COUNTY COUNCIL'S RESPONSE TO CONSULTATION ON THE FOLLOWING DEVELOPMENT PROPOSAL

Application No: 18/01333/F

Proposal: Extension to existing Technical Site to provide new employment units comprising flexible B1(c) light industrial, B2 (general industrial), B8 (storage or distribution) uses with ancillary offices, storage, display and sales, together with associated access, parking and landscaping.

Location: Bicester Heritage, Buckingham Road, Bicester.

FIGURE 12: ENVIRONMENT AGENCY 1% AEP SURFACE WATER MAP FOR THE SOUTHERN AREA

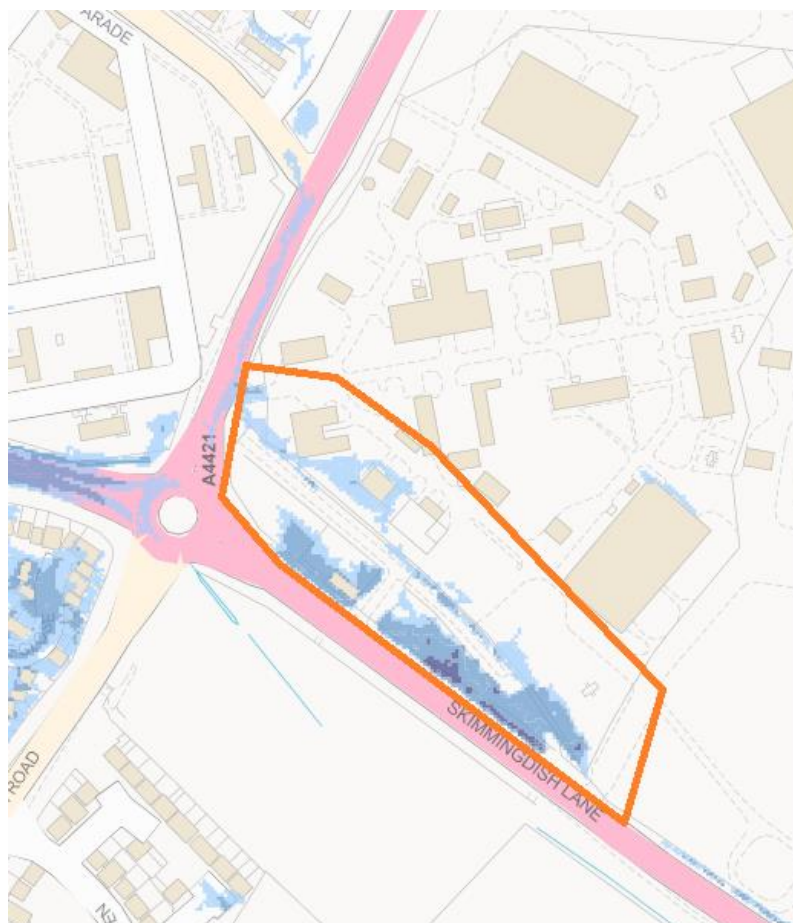
- OCC (Drainage) have raised an objection to the application as it is not clear whether infiltration testing has been undertaken at the site itself and also do not consider that sufficient information has been provided within the drainage strategy regarding the strategy to manage the high and medium probability of surface water flooding on the southern site.

- OCC (Drainage) have raised an objection to the application as it is not clear whether infiltration testing has been undertaken at the site itself and also do not consider that sufficient information has been provided within the drainage strategy regarding the strategy to manage the high and medium probability of surface water flooding on the southern site.

Title **Drainage Layout Sheet 1 of 2**

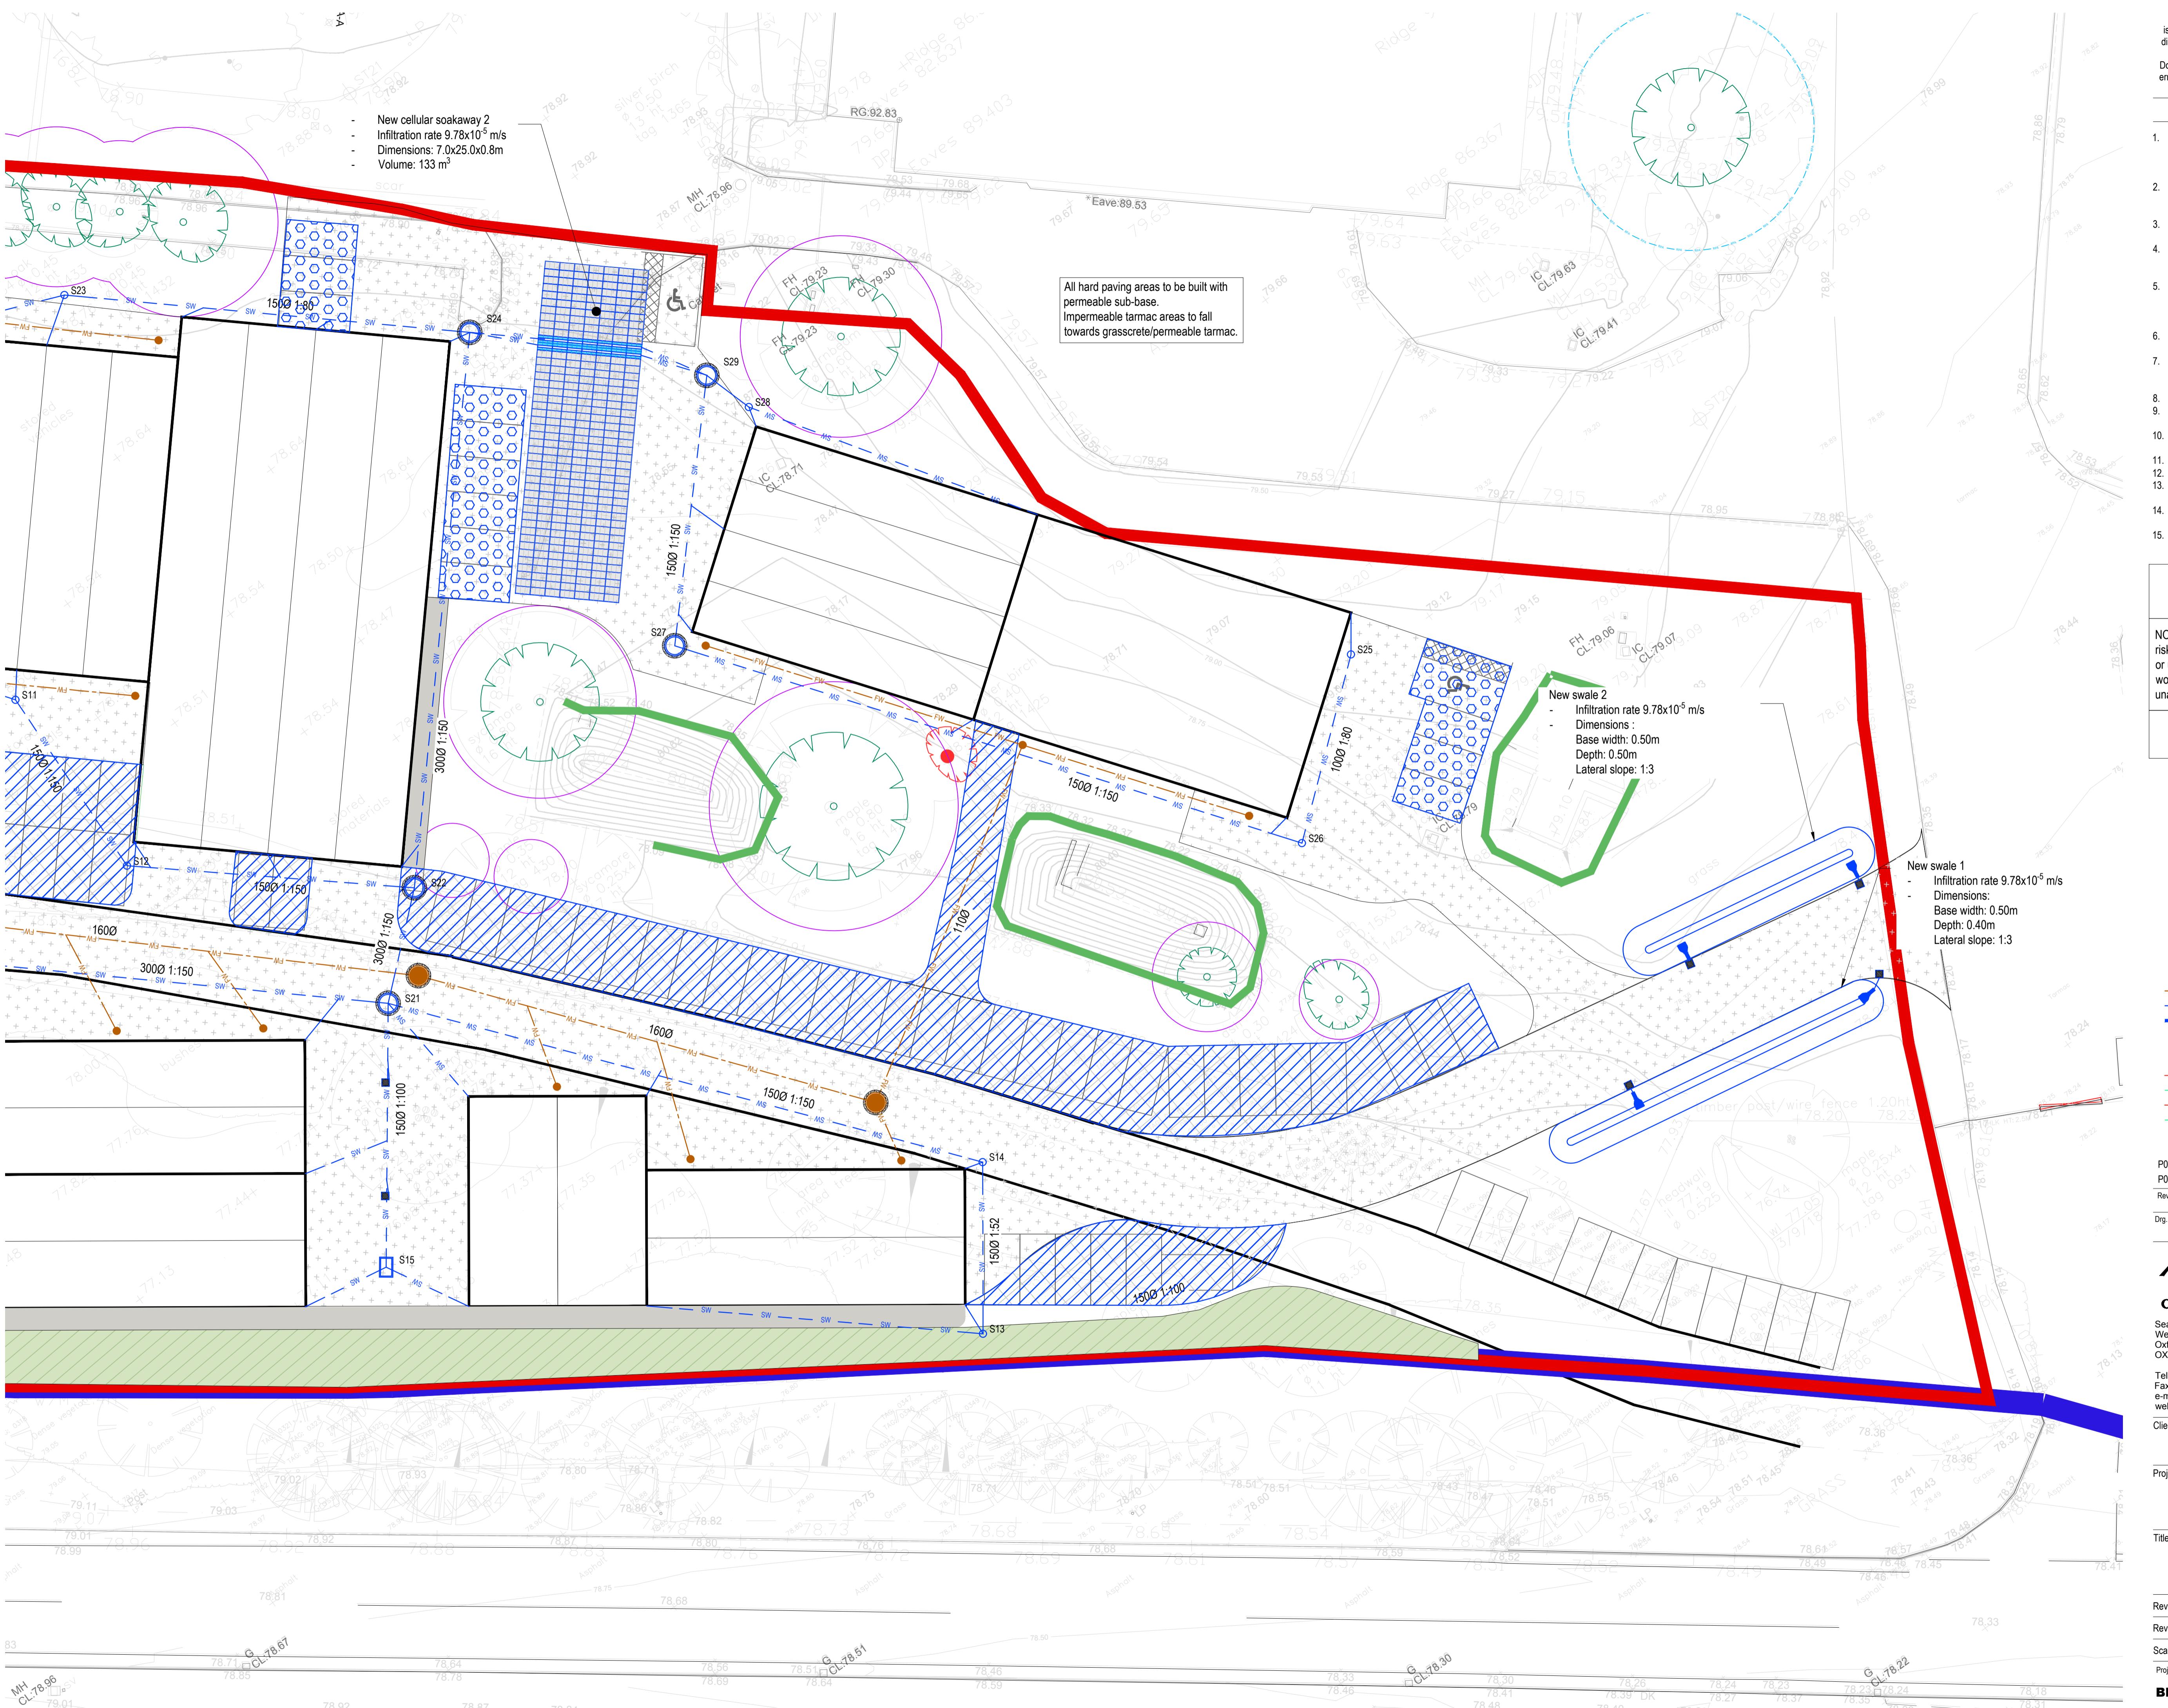
The SuDS proposals for this site include the use of Permeable Paving, Swale and an underground geo-cellular soakaway. The drainage strategy reports infiltration rates
